DECISION DELEGATED TO DEVELOPMENT MANAGER

Application No: H12-0190-20 **Applicant:** Mr & Mrs S Laker
Proposal: Extension and Alterations
Location: Oakwood Marriots Gate Luton
Terminal Date: 27th July 2020

PROPOSED SHADOWS

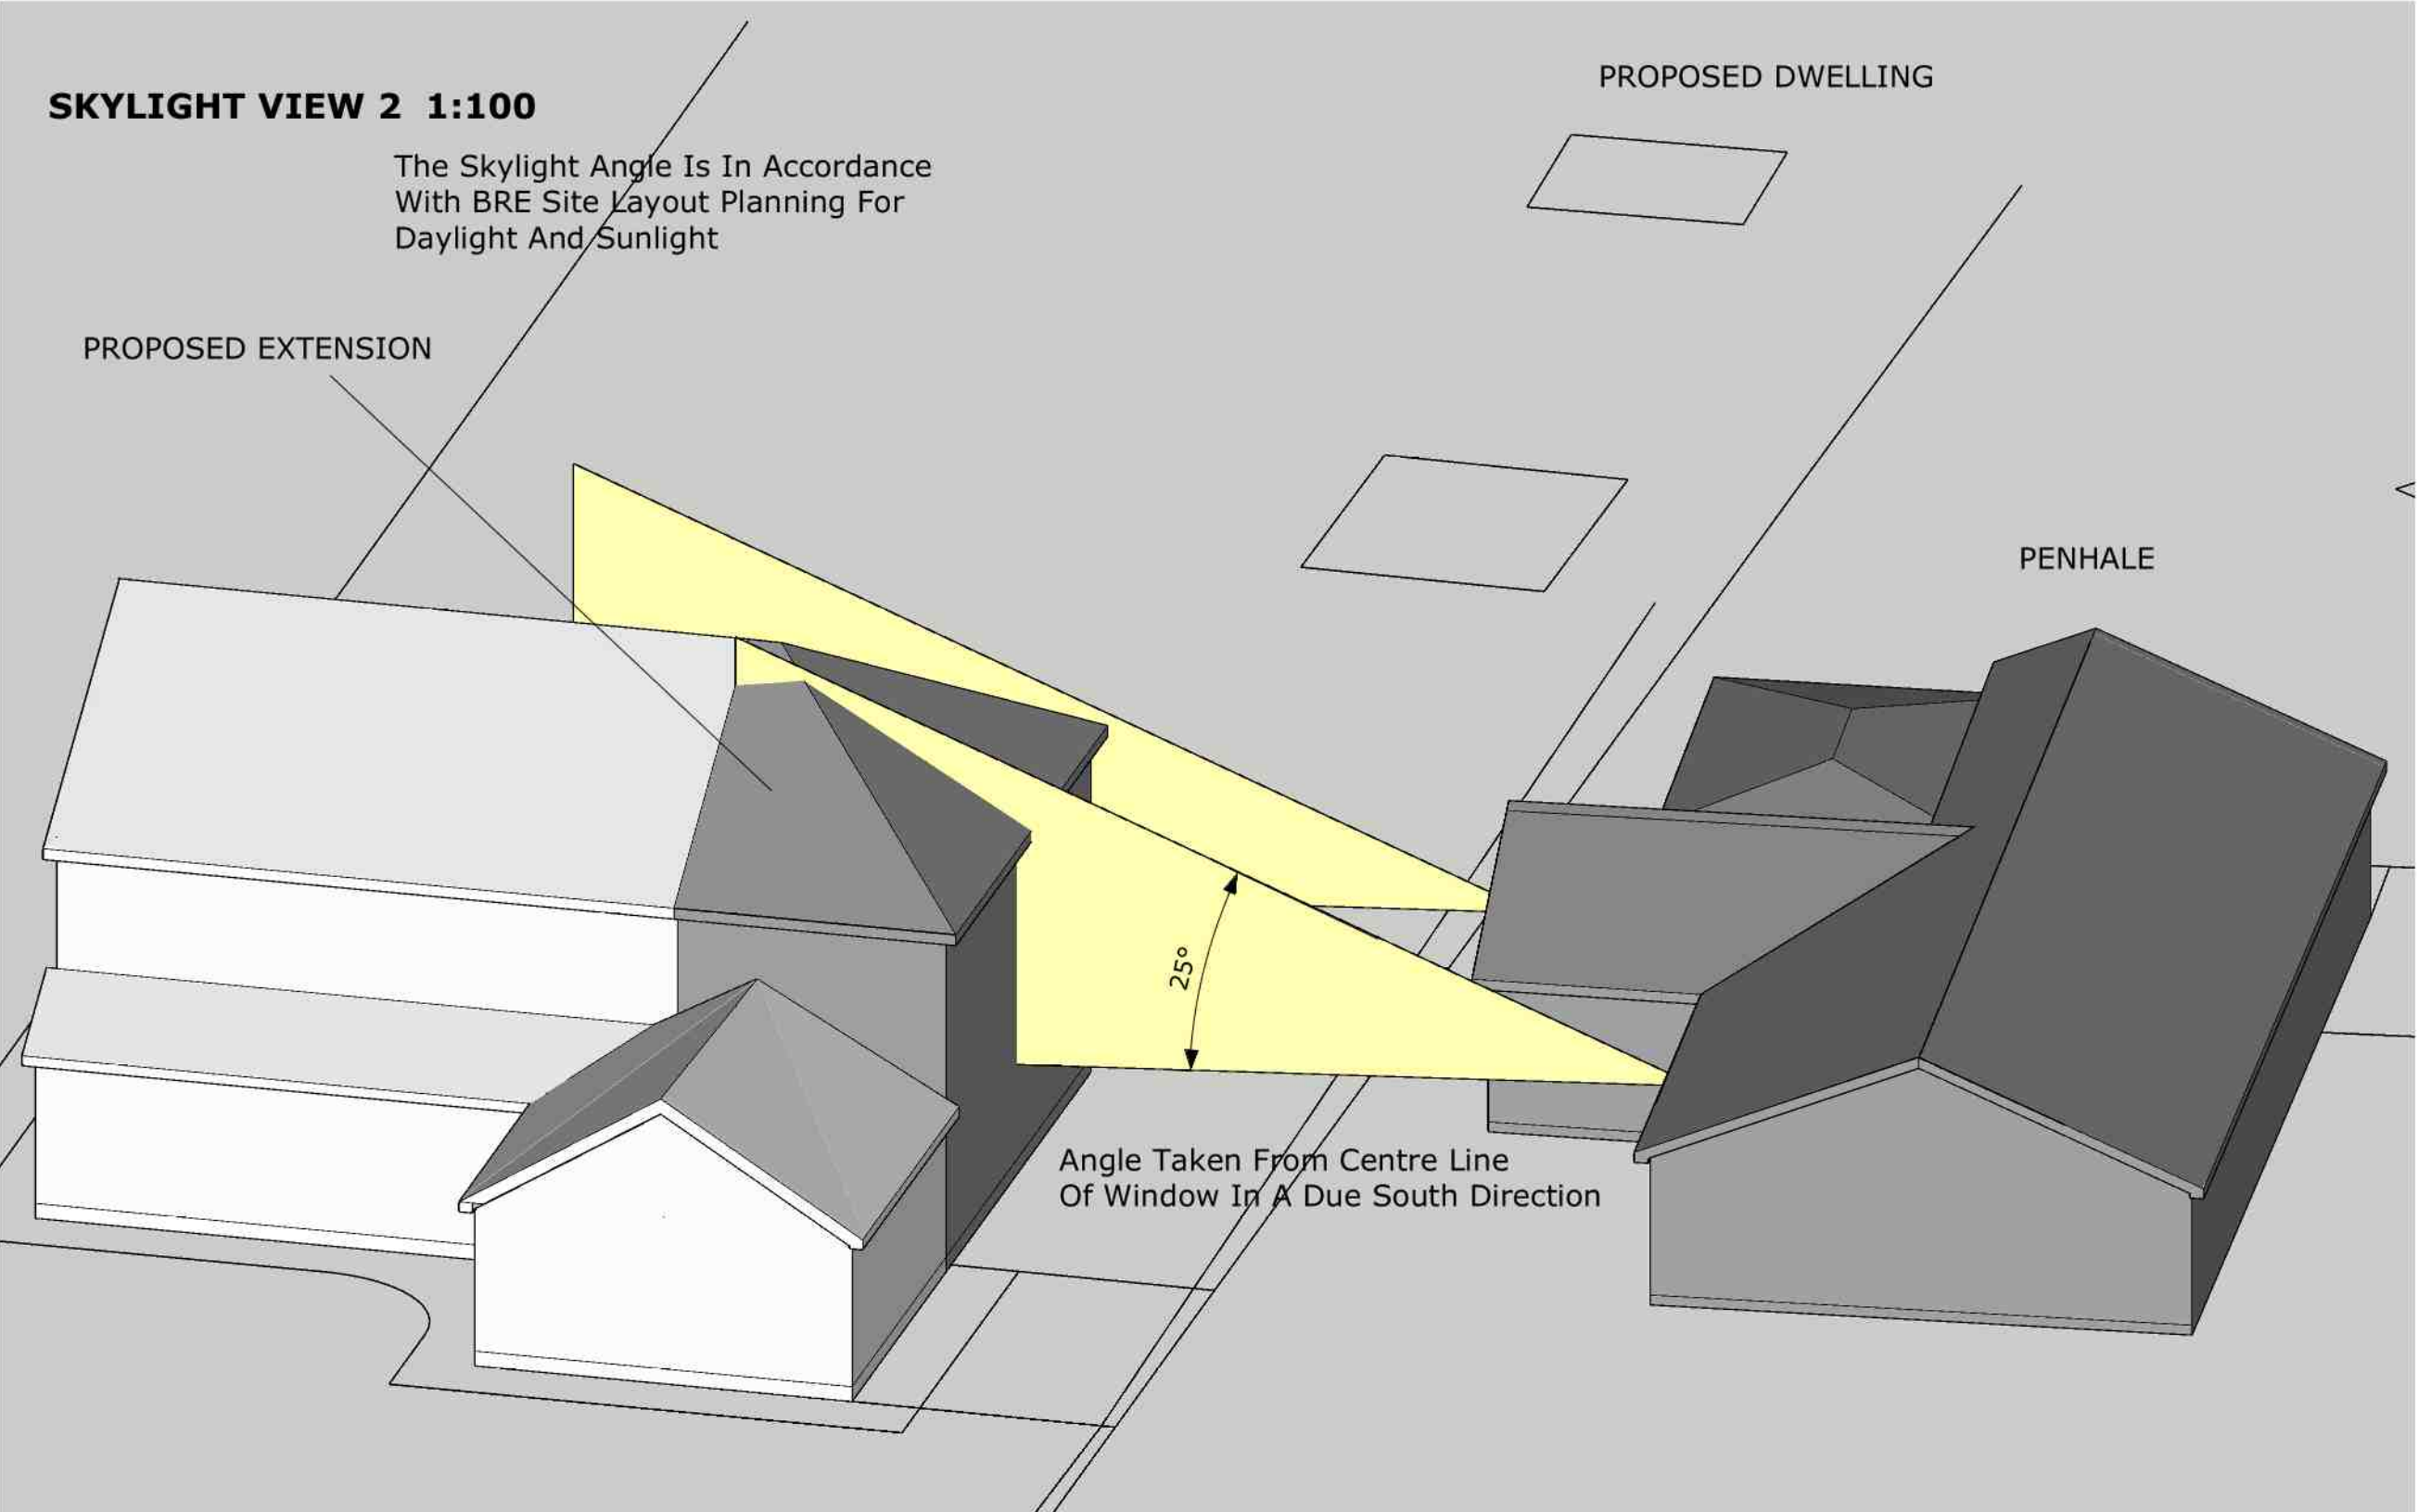
The BRE '25 degree rule' is a test to ascertain the likely effect a proposed development will have on an adjacent building with regards to obstructing daylight to existing windows/rooms. This test is applied on Dwg. No 3620-20-03 and the 25 degree angle appears to be complied with. Notwithstanding this, the applicant has submitted further plans which show the likely shadowing based on the height of the sun at 10am and 2pm on 21st December (winter solstice). This shows that the closest window to the proposed extension (lounge) is already overshadowed by the dwelling as existing at 10am on that date. At 2pm, the proposed extension would only very marginally interfere with the side facing dining room window, by a matter of a few centimetres. In light of this, it is not considered that the likely impact in terms of daylight levels and warmth is so significant as to warrant refusal of the application.
